June 9, 2023

Reference: Engineering Services
Serenity - Lot 55
114 Serendipity Dr.
Fuquay-Varina, NC 27526
TE&D Project No.: 2301-020472_A

1. Inspect and analyze the cut pre-engineered roof truss. We understand the truss was cut at the bottom chords to accommodate an LVL beam.

David Weekley
 55 Serenity
COMPONENT PLAN

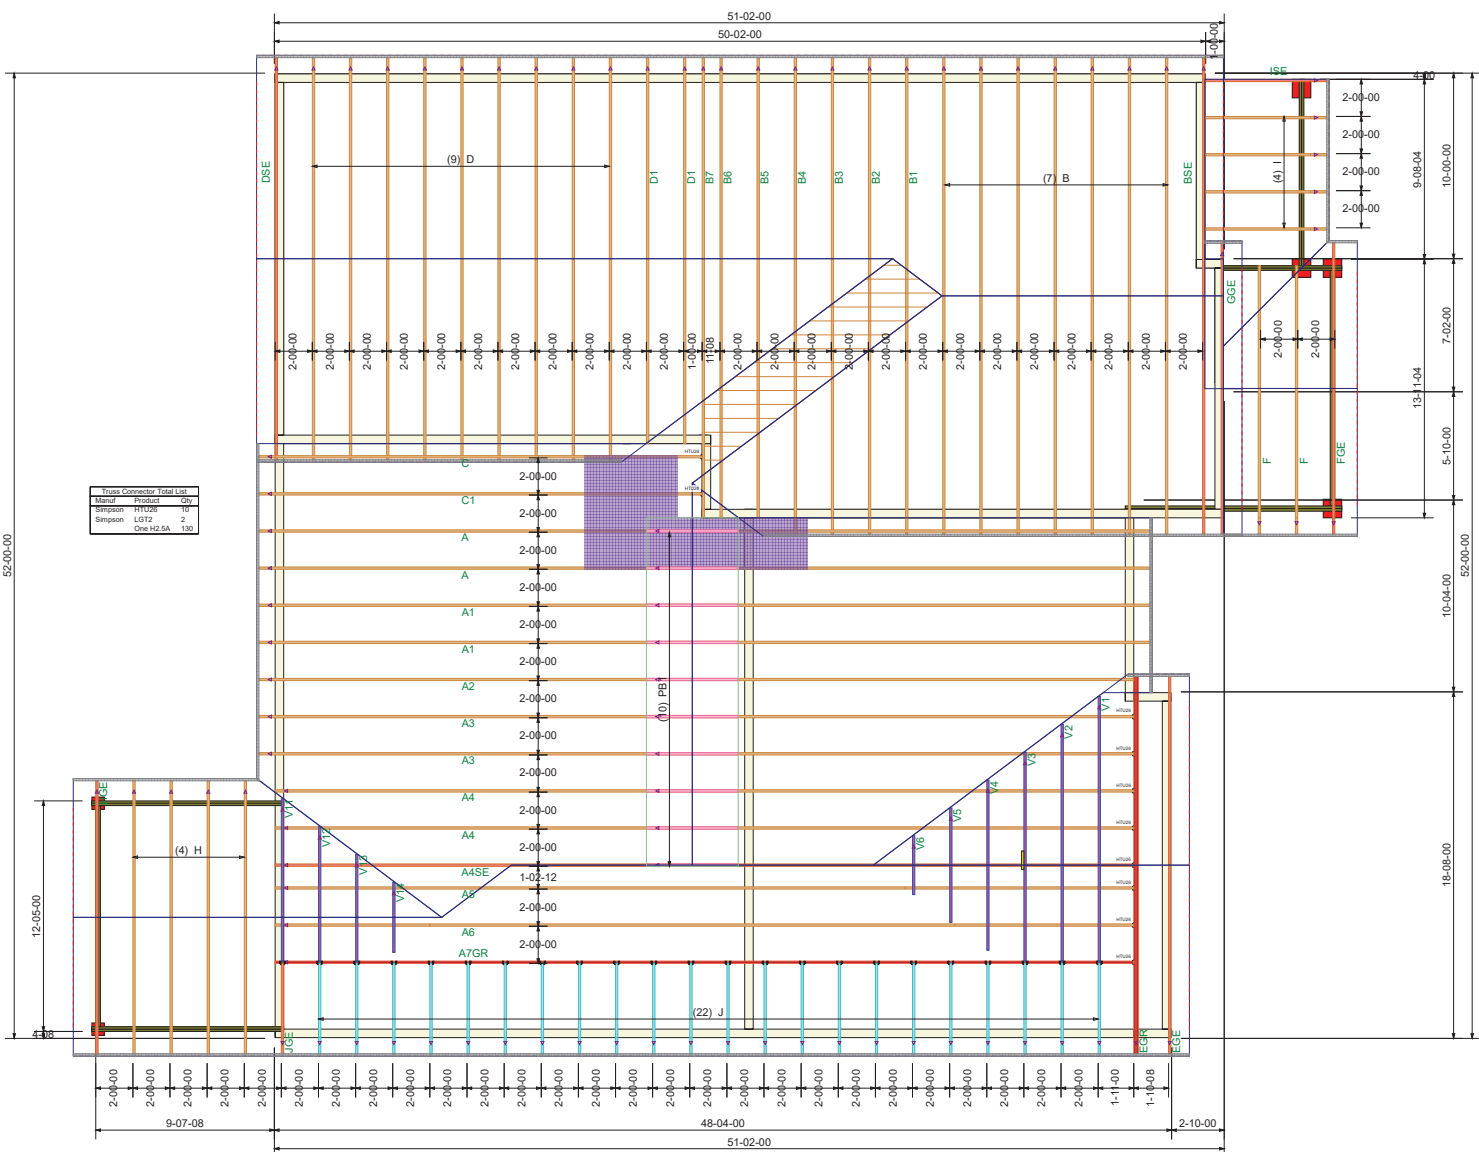
1. We observed roof truss "A" was cut at bottom chords 24-25, 23-26, as well as web 23-24. Based on our observations and analysis, the existing truss is not suitable as installed due to the anticipated compression and tension loads associated with the damaged members. The truss is to be repaired and reinforced with the following recommendations:

- a. Each side of the LVL beam is to be furred out with 7/16" OSB sheets as needed. Sheets are to be fastened to the beam with (3) rows of 8d nails at 4" o.c. Sheets are to extend to adjacent intersecting members on each side of the damaged truss.

- b. The bottom chord (floor portion) of the truss, from point 16 to 33 is to be fully sheathed with OSB sheets. OSB is to be a minimum 7/16" and is to be fastened to all members with (2) rows of 8d nails at 4" o.c. OSB is only required on (1) face of the truss.

- c. Face mount truss hangers are then to be installed to support the bottom of the truss on both sides of the LVL. Hangers are to be installed on the OSB and fastened per the manufacturer's specifications.

- d. Both sides of the cut truss are then to be reinforced to resist anticipated tension loads. The top and bottom chords of the "floor section" are to be reinforced with a Simpson LTTP2 Tension Tie (or equivalent). Ties are to be fastened with 10d nails or SD screws at all holes. The base is to be fastened to the LVL beam with a minimum 3" long x 1/2" diameter SDWS screw (or equivalent).
